Elizabeth Elenius, Convenor
9C/2 Bowman Street
PYRMONT NSW 2009
Tel: 9571 9727; 0409 552 117
Email: eelenius@bigpond.net.au
www.pyrmontaction.org.au

30 July, 2018

Response to Submissions – Cockle Bay Wharf (SSD 7684)

Fig. 28. Envelope extension to south

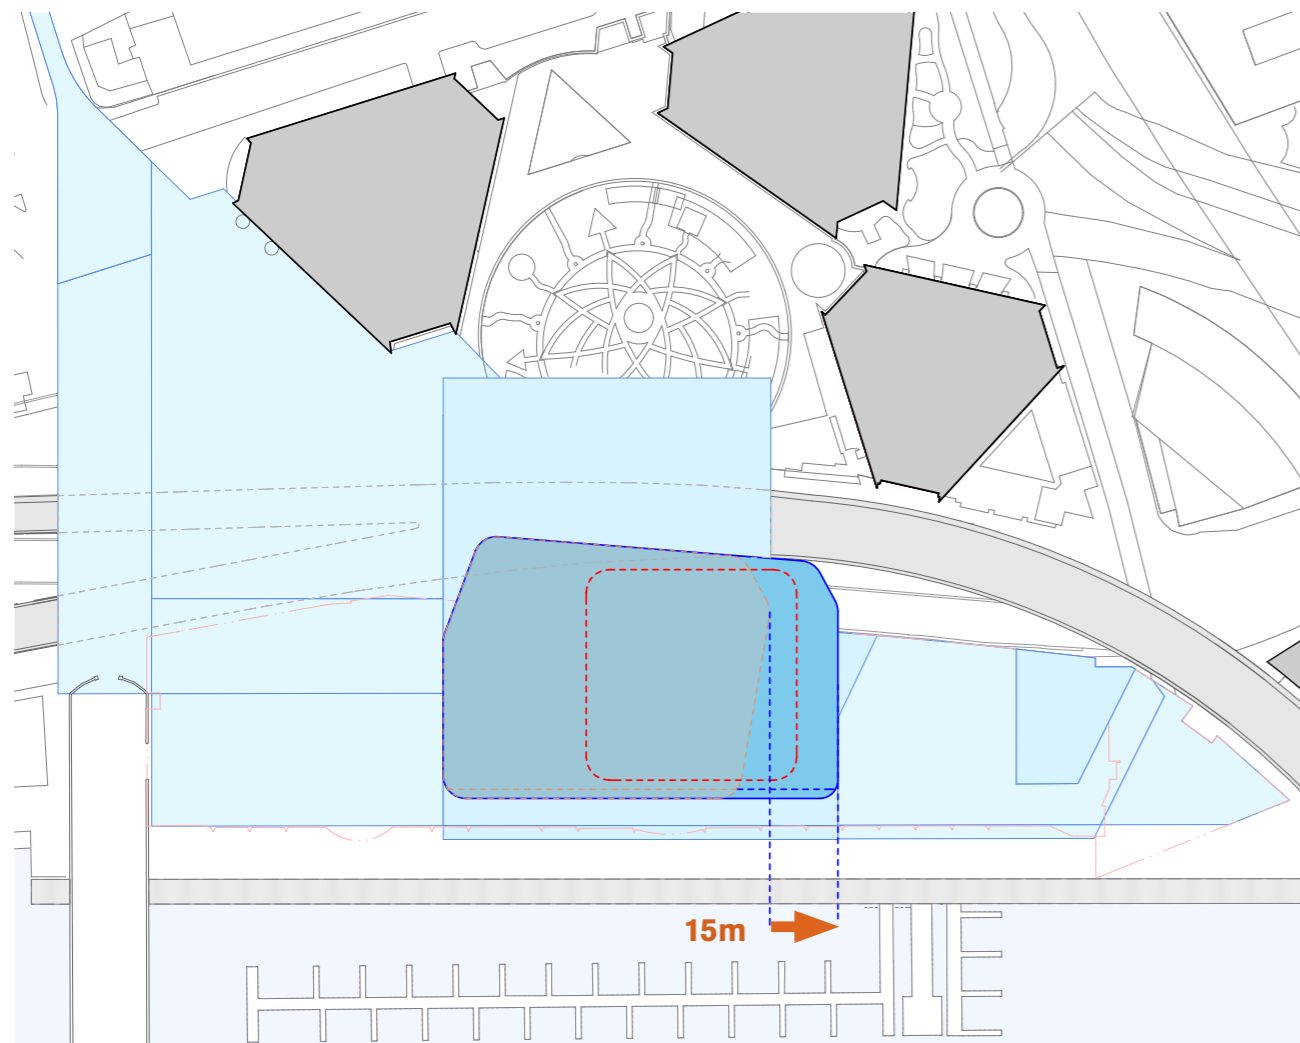
Scale of Project – Whilst a further reduction in height of 12m has been proposed, it appears that the overall scale of the tower and podium has not been markedly reduced as the Southern façade of the tower has been extended 15m further south, even taking into account the movement of the northern tower façade 8m further away from the Pyrmont Bridge. It is proposed that the tower will accommodate approximately 42 commercial storeys, far more than the 35 storeys we proposed in our recommendations (4 December, 2017), although it is unclear whether this includes the storeys associated with the podium. We are advised that the proposed building envelope in the Concept Plan allows flexibility for the stage 2 design excellence process, and the Response (Appendix C, p51) indicates that the final design will be subject to controls and that only 65% of the tower volumetric utilization will prevail, providing certainty that the whole envelope will not be filled. Our recent experience with other large developments or those approved under the former “rules free” Site of State Significance provisions, leads

that the building envelope be further reduced both in height and bulk and that controls such as those outlined on p51 Appendix C be mandated in such a way that no later Modification of Development can be submitted by the developer to alter the approved controls.

Fig. 30. Envelope increased Promenade setback

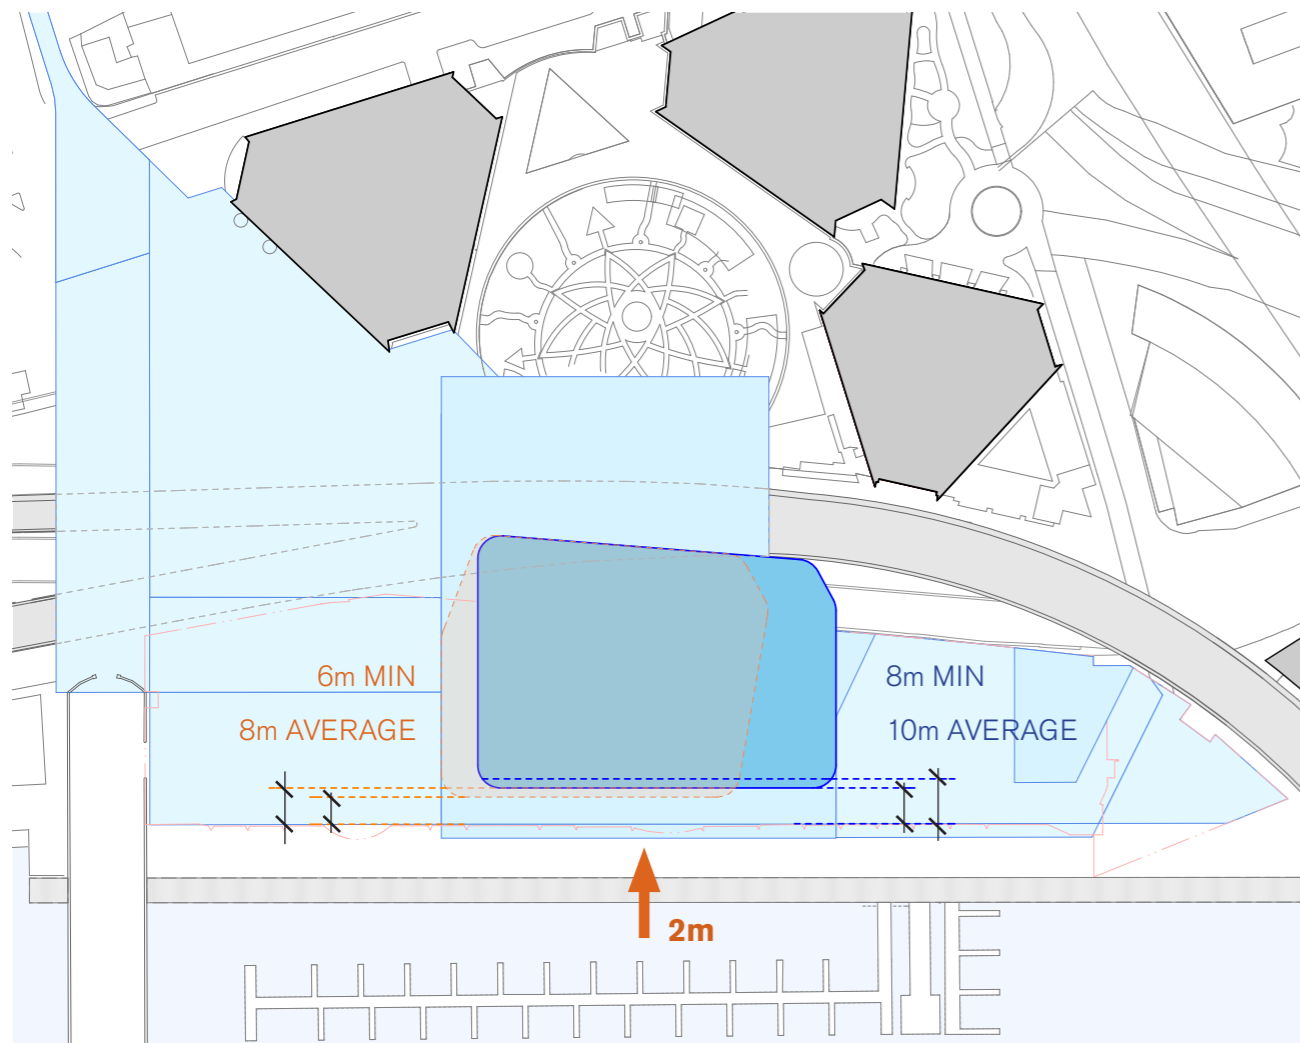
Building Placement – Whilst the Tower has been moved a further 8m away from the Pyrmont Bridge, the podium has been moved only 2m further from the water, and the proposal endorses the alienation of the harbour by the provision of an over-the-water boardwalk to provide space for pedestrian movement. We recommend: *the setback of the podium should be no less than 24m to ensure that there is no prospect of encroachment over the harbour.*

the setback of the podium should be no less than 24m to ensure that there is no prospect of encroachment over the harbour.
